Application for a non-material amendment following a grant of planning permission.

Variation of condition 2-plans condition imposed under BE/56/20/HH.

change permitted dormer windows from gabled to hipped

CLIENT	PROJECT	TITLE	STATUS	DRAWN BY	REVIEWED BY
C TOMKINS	REAR OF 99 NORTH BERSIED STREET	PROPOSED ELEVATIONS	PLANNING	SJ	SJ
			DATE	SCALE	DRAWING NUMBER
			14.12.2020	1:100@A3	17B

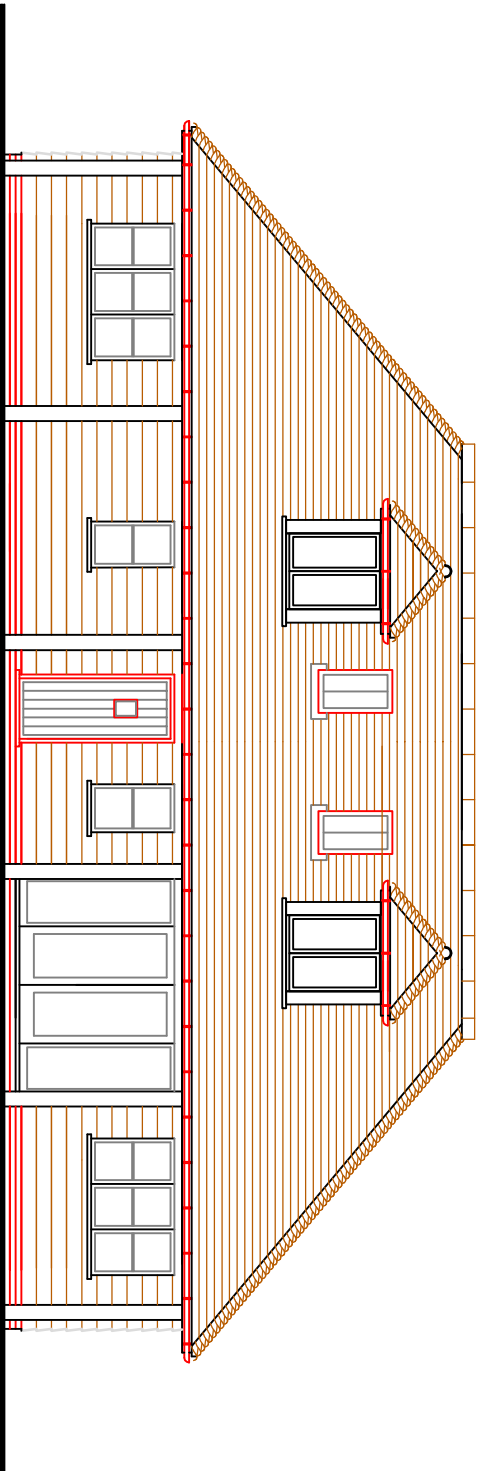
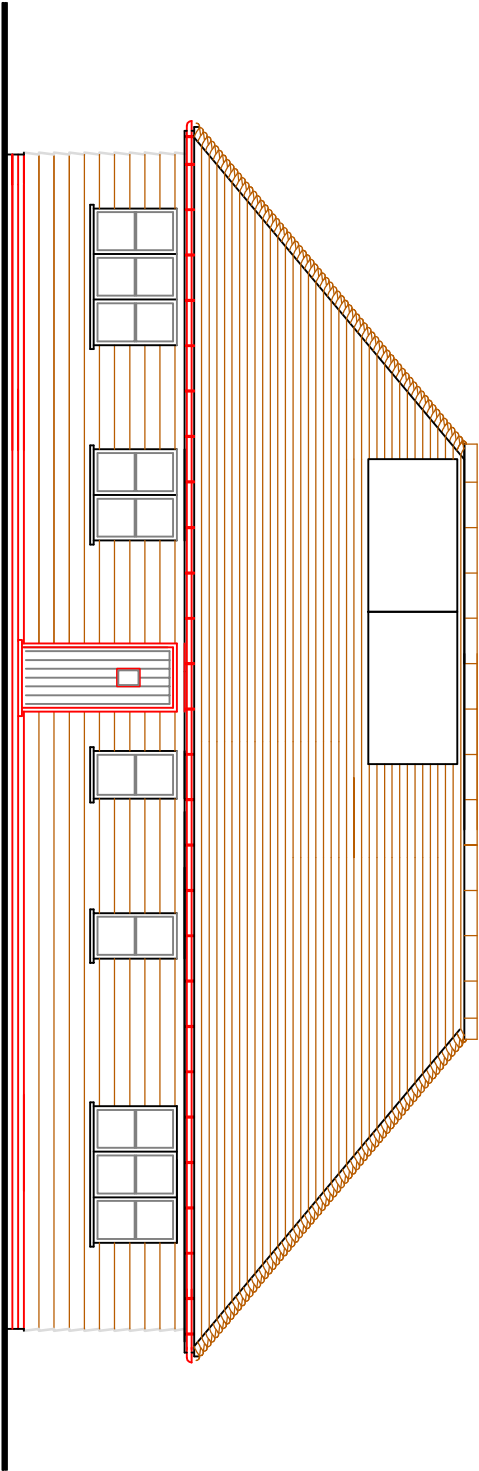
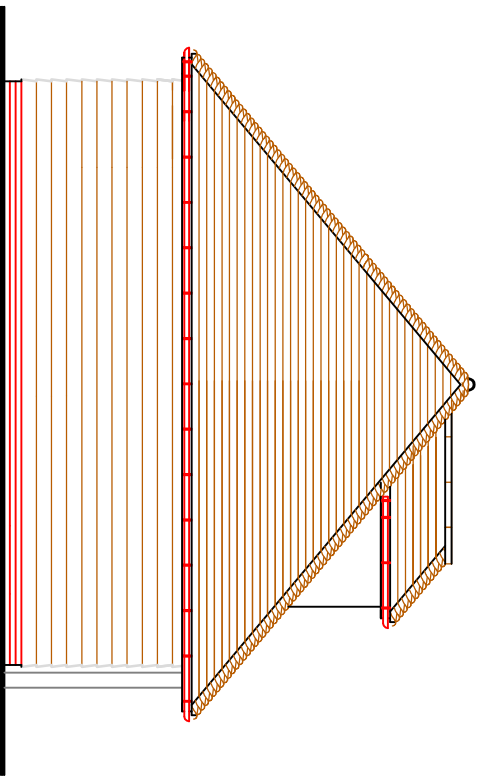
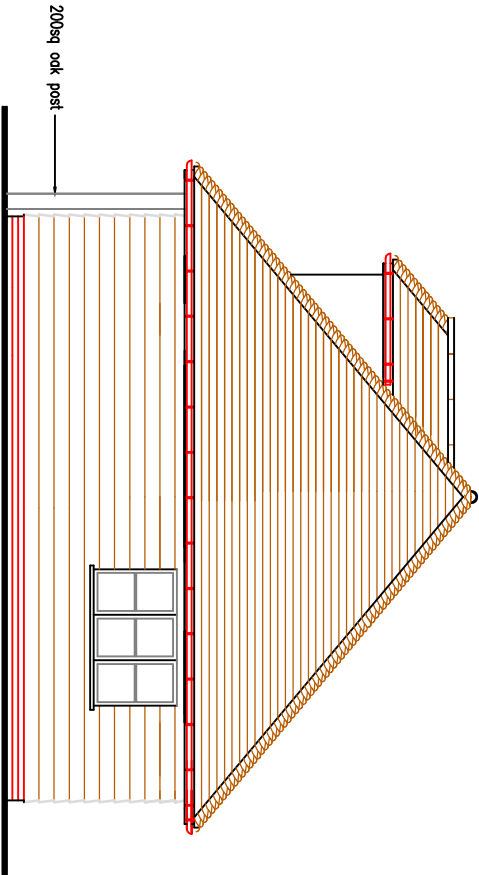
so that dormer roofs match the main hipped roof
